# Rezoning Transportation Analysis

Petition Number: #2022-168

Date	Description
02-22-23	First Review (TM)
03-23-23	Second Review (TM)

PROJECT:
THE MARQUEE
TAPAS AND LOUNGE

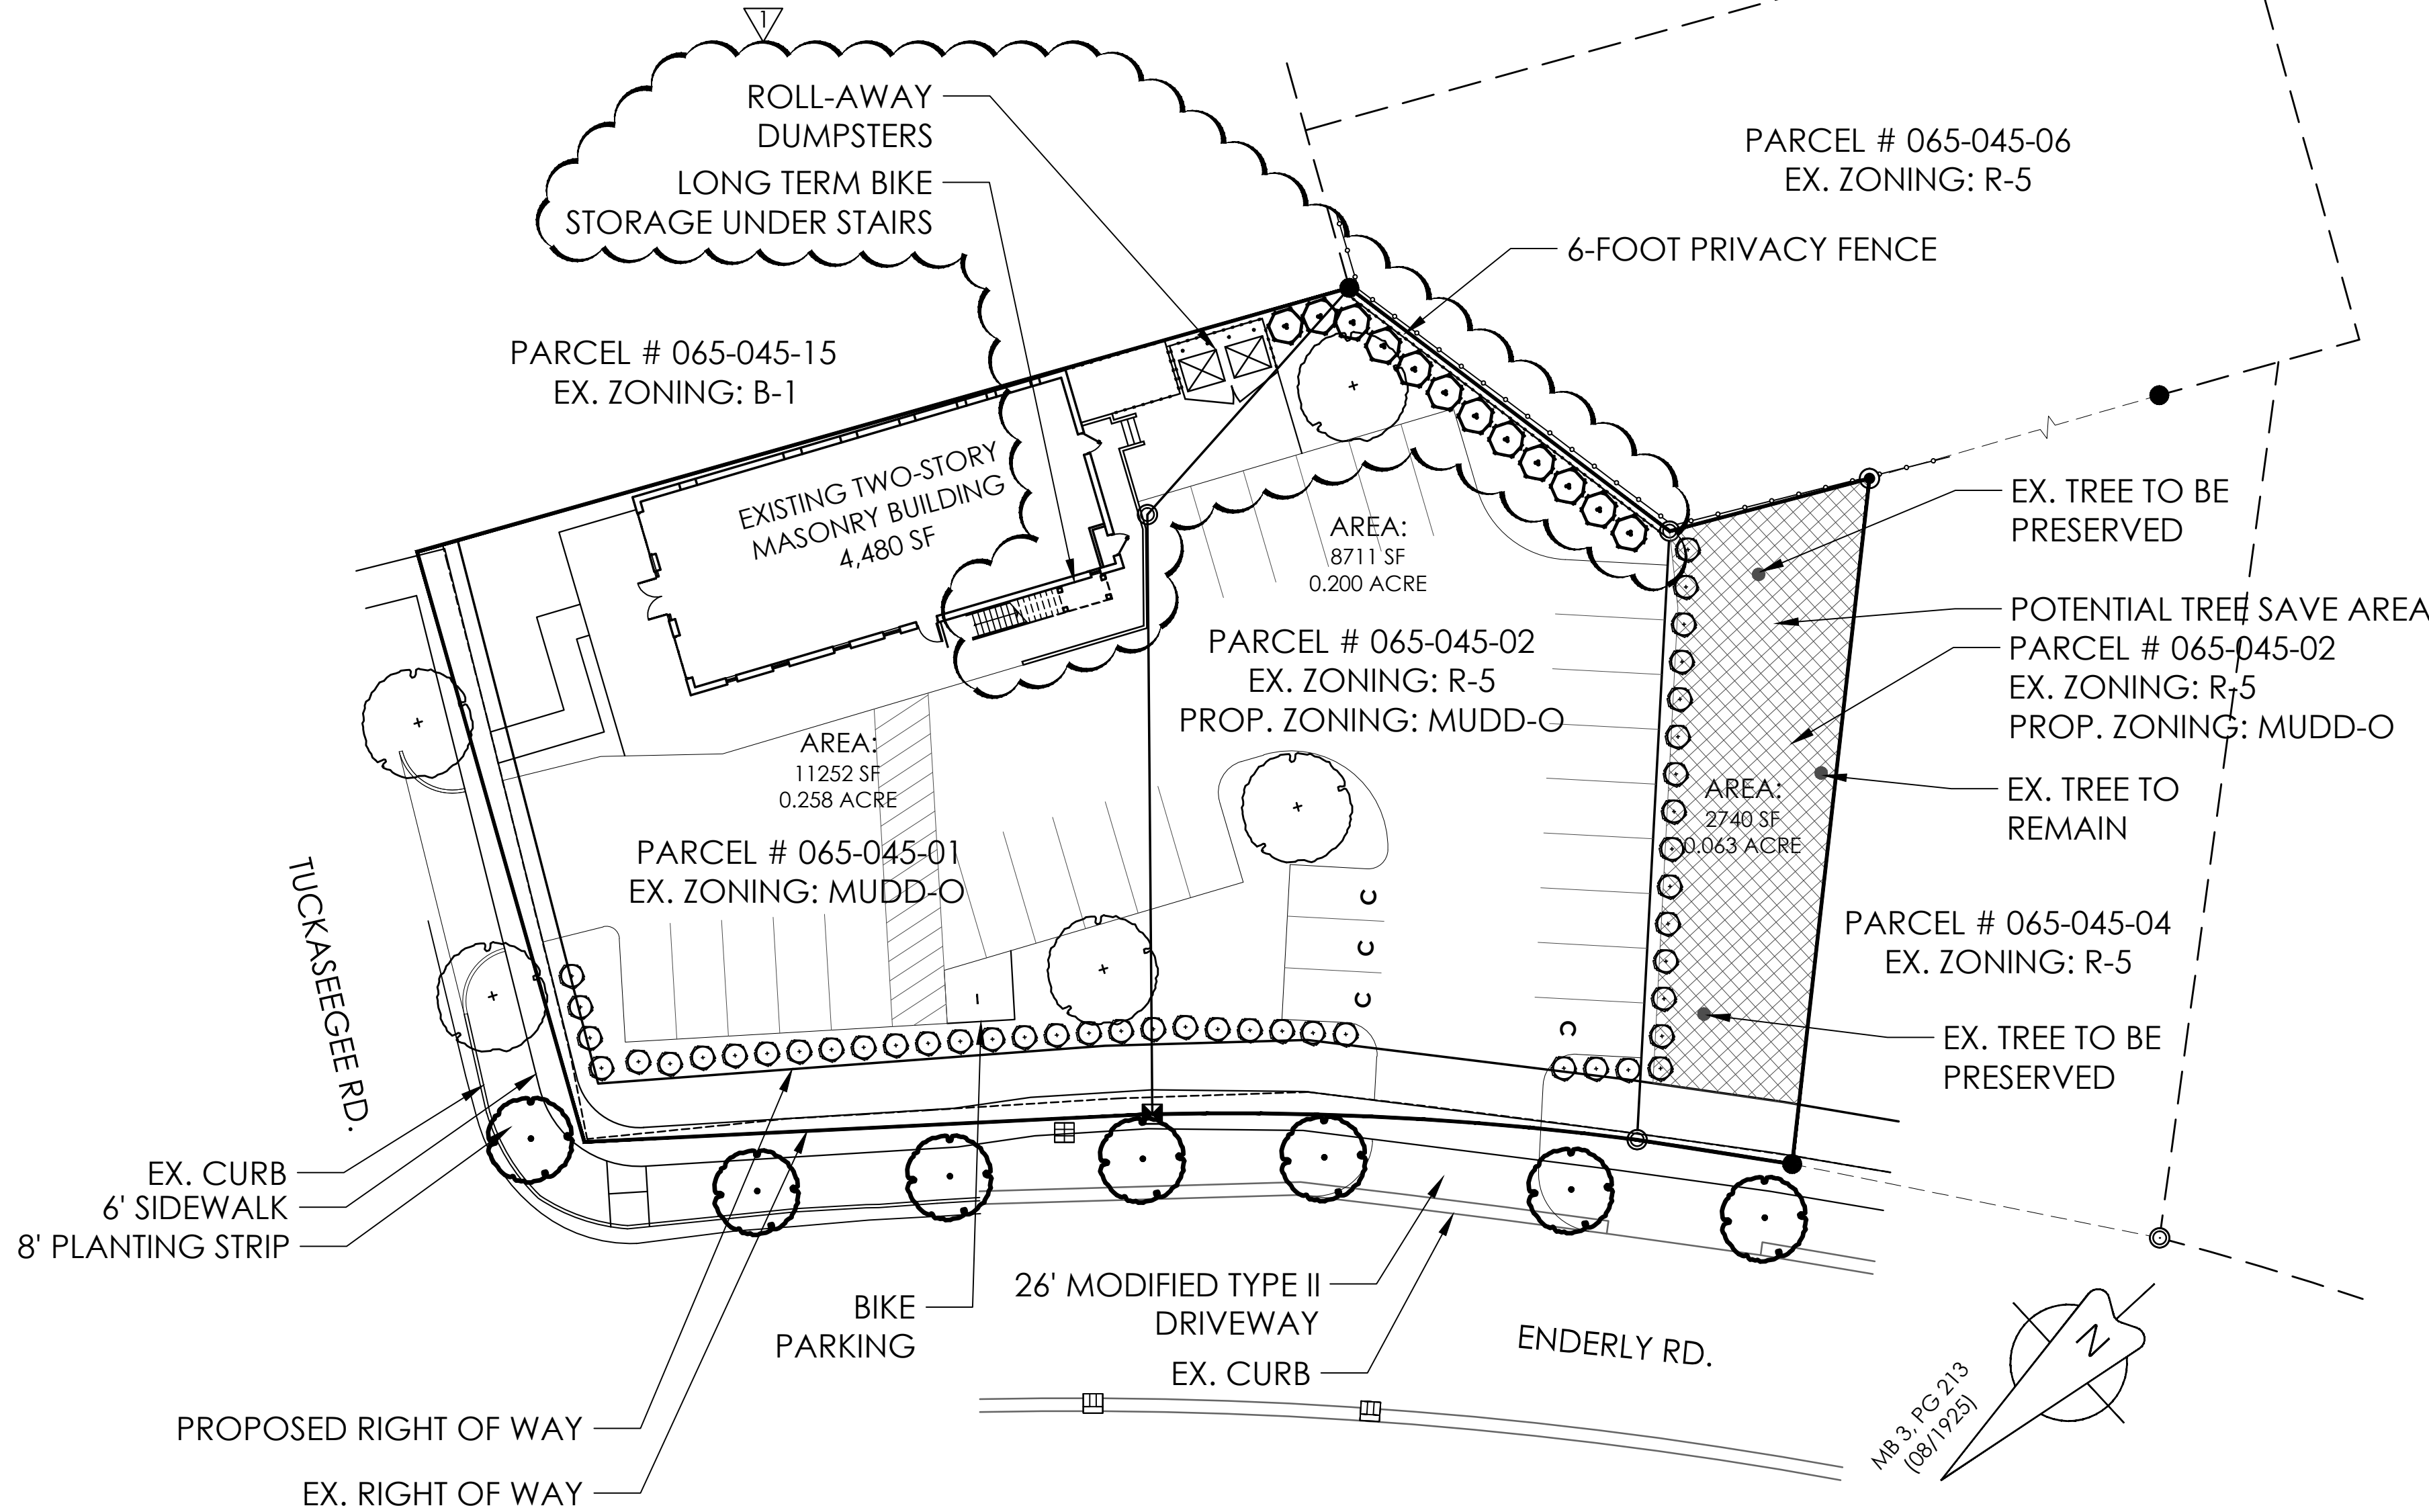
- Outstanding Comment from 02-22-23: Tuckaseegee Road:** Location of curb and gutter to be moved to 27 feet from roadway centerline to accommodate the Charlotte Streets Map with a roadway typical section of a 2+ Avenue, Buffered/Separated Bike Lanes. Show future curb line on site plan and dimension planting strip and sidewalk from the future back of curb location.

**Outstanding Comment from 02-22-23:** Label and dimension the curb and gutter from the centerline for each road on the site plan.

- CDOT REQUEST:** that site plan and conditional note(s) revisions are made to commit to construct an 8-foot planting strip, and 8-foot sidewalk on Tuckaseegee Road to match the overall city plan for this street section per Charlotte Streets Map. The site plan shall label and dimension both items from the future back of curb and gutter. The wider sidewalk also meets the Charlotte WALKS Policy

6. **Outstanding Comment from 02-22-23:** Add a conditional note specifying "A Right-of-Way Encroachment Agreement is required for the installation of any non-standard item(s) (irrigation systems, decorative concrete pavement, brick pavers, etc.) within a proposed/existing City-maintained street right-of-way by a private individual, group, business, or homeowner's/business association. An encroachment agreement must be approved by CDOT prior to construction/installation. Contact CDOT for additional information concerning cost, submittal, and liability insurance coverage requirements."
